**KIRKLEES METROPOLITAN COUNCIL
INVESTMENT & REGENERATION SERVICE**

DELEGATED DECISION TO DETERMINE PLANNING APPLICATIONS

Reference No:	2024/62/92372/E
Site Address:	1, Tabbs Lane, Scholes, Cleckheaton, BD19 6DY
Description:	Erection of single storey front extension
Recommending Officer:	Faiza Bano

DECISION – Conditional Full Permission

Proposed Plans/Elevations

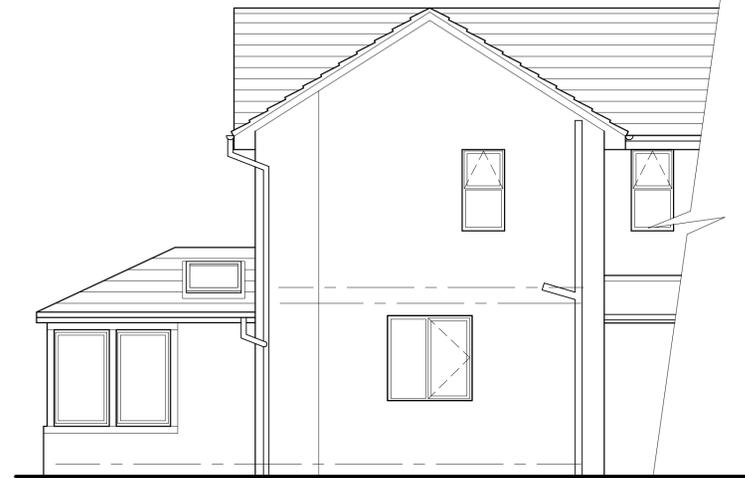
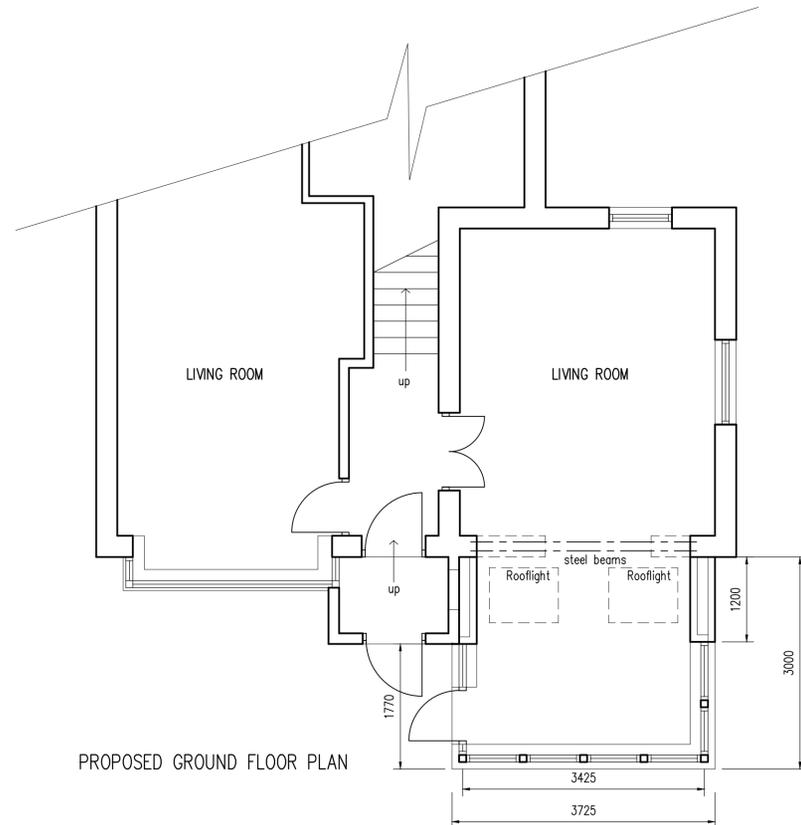
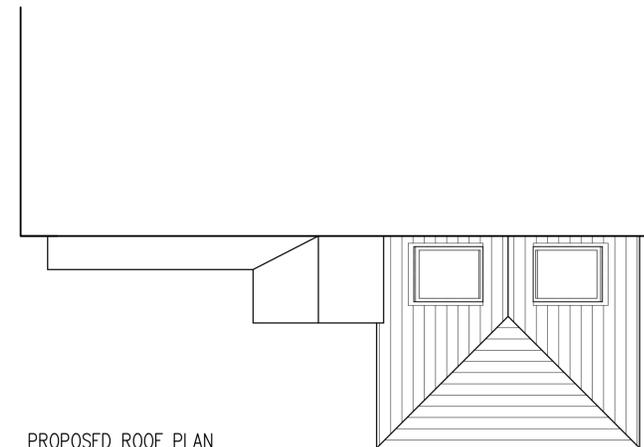
The proposal would not extend beyond the front elevation of No.3 which is considered to be within the same building group.	
The extension is small, subservient to the original building,	Yes – although having an overall projection of 3.0m (though 1.7m from the existing porch), the extension would still appear subservient in relation to the host property and has been designed with a pitched roof, in-keeping with host property.	
The materials and design match the existing features of the original house; and	Yes – materials would match existing	
The extension would not unreasonably affect the neighbouring properties.	Yes – the modest scale would result in minimal impact on neighbouring property.

<ul style="list-style-type: none"> • Policy LP24 Design (a) and (c) of the KLP • Chapter 12 NPPF 	<p>detached nature, positioning and orientation of the extension, the proposed development would not appear overly prominent, being relatively well screened and not extending beyond the line of No.3 to the east. The proposed development would be located to the front of the property and will not impact the character or street scene.</p>	
Impact on original house	<ul style="list-style-type: none"> • KDP2 of the SPD • Policy LP24 Design (c) and (d) of the KLP • Chapter 12 of the NPPF 	The original property would remain the dominant feature.	✓
Height, scale and massing	<ul style="list-style-type: none"> • KDP 1 and 2 of the SPD • Policy LP24 Design (a), (c) and (d) of the KLP • Chapter 12 of the NPPF 	As above. The extension would project across the front of the property and is single storey.	✓
Facing materials and detailing	<ul style="list-style-type: none"> • KDP 9 of the SPD • Policy LP24 Design (d) (iii) of the KLP • Chapter 12 of the NPPF 	Facing materials to match existing.	✓

Roof style	<ul style="list-style-type: none"> • KDP 1 and 2 of the SPD • Policy LP24 Design (a), (c) and (d) of the KLP • Chapter 12 of the NPPF 	Pitched roof style – acceptable as it is in-keeping with the original roof style of the host property.	✓
Window proportions	<ul style="list-style-type: none"> • KDP 1 and 2 of the SPD 	Modest size windows in extension, which would	✓

<ul style="list-style-type: none"> • Policy LP24 Design (a), (c) and (d) of the KLP • Chapter 12 of the NPPF 	be in-keeping with existing building.	
Accessibility for all users	<ul style="list-style-type: none"> • KDP 17 of the SPD • Policy LP24 Design (f) • Chapter 12 of the NPPF 	Private domestic extension which would provide easy access into the main house.	✓
